Re: Amended Site Plan for Diver Down, 399 Presumpscot Street
CBL: 420 A007001

On October 8, 2003, the Portland Planning Authority granted minor site plan approval for the site improvements at 399 Presumpscot Street, as shown on the approved plan with the following condition:

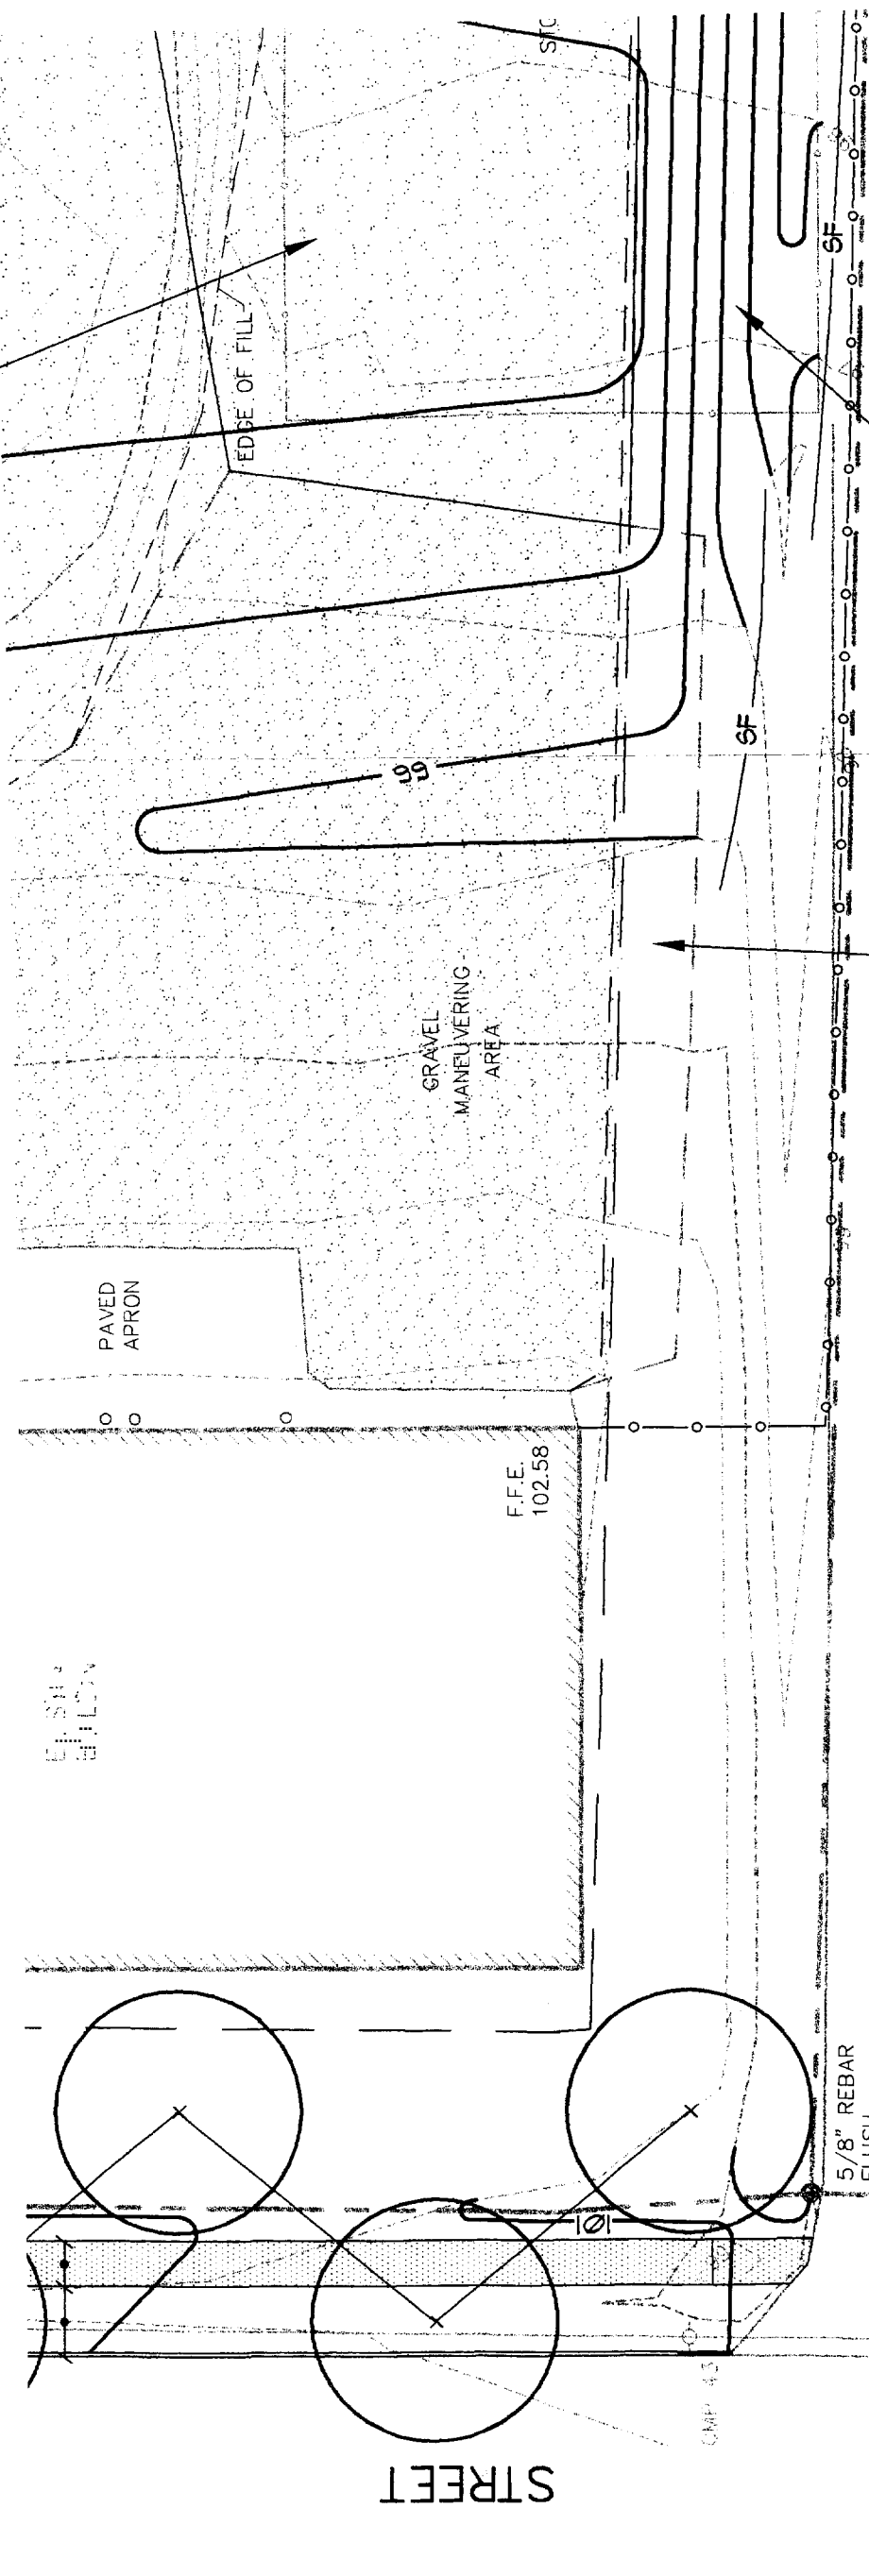
That the esplanade along the property frontage be widened to eight feet (thereby moving the sidewalk back three feet), and planted with two 3" caliper Honey Locust street trees. Also, that the three trees shown in the front yard should also be Honey Locust.
